# CITY OF ALBUQUERQUE

**Re: Site remodel, Bldg A, Bldg B, Bldg C**  
**3300 2<sup>nd</sup> St.**  
**Request for Certificate of Occupancy**  
**Transportation Development Final Inspection**  
Engineer's/Architect's Stamp dated 4 – 9 - 18 (G14-D091)  
Certification dated 08 - 17- 2018

REMODEL
SITE PLAN

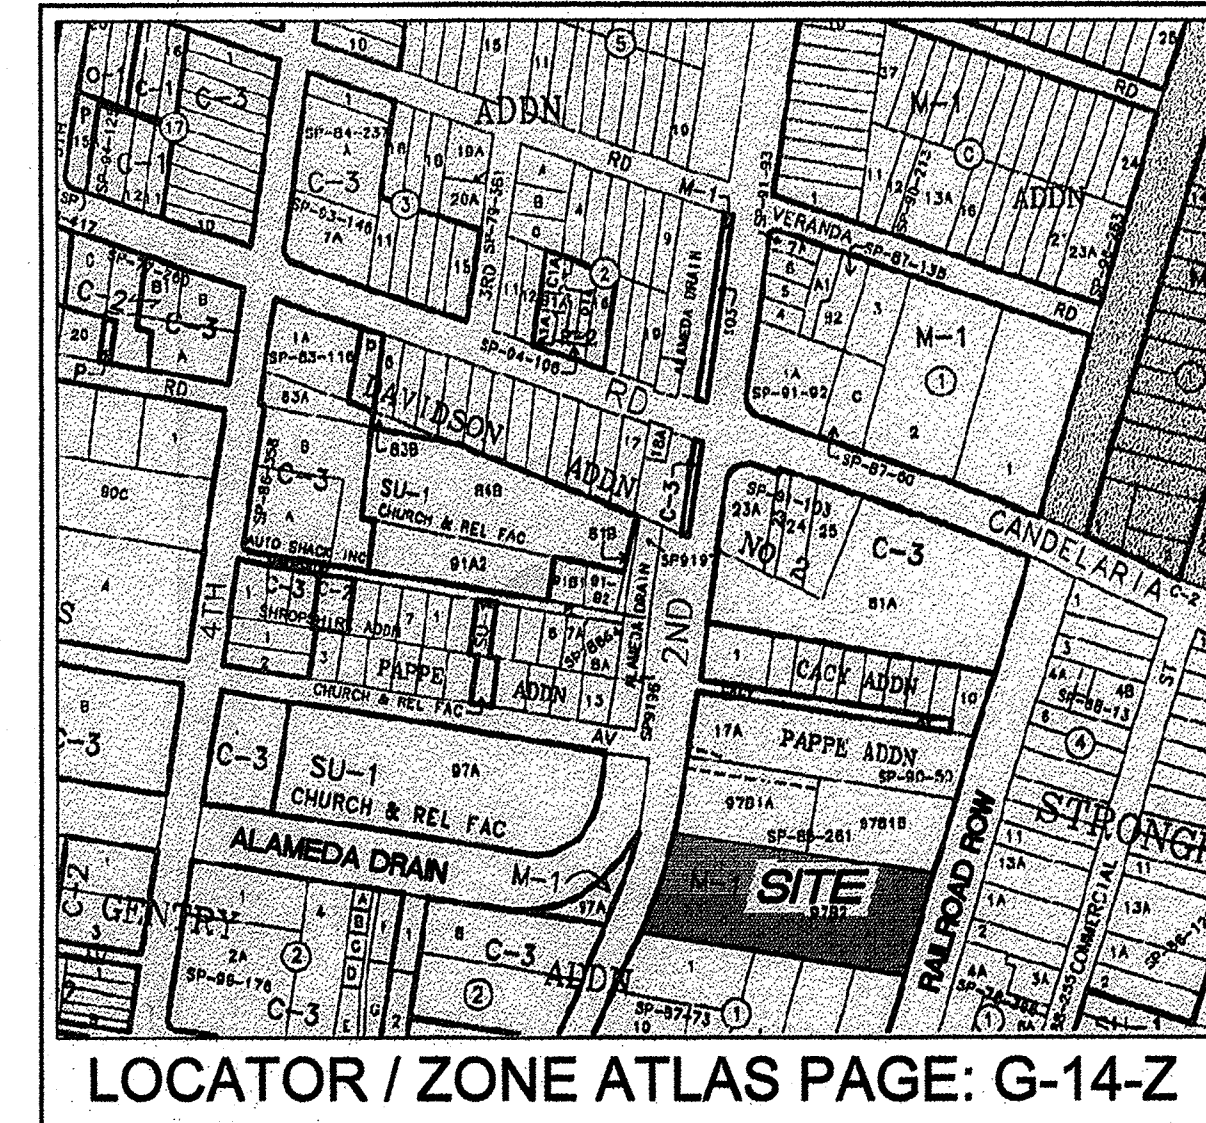
- Provide approved TCL along with changes in parking spaces distinguished in red
- Place refuse containers
- Remove parking bumpers from the front of the building A
- Remove construction fence and debris
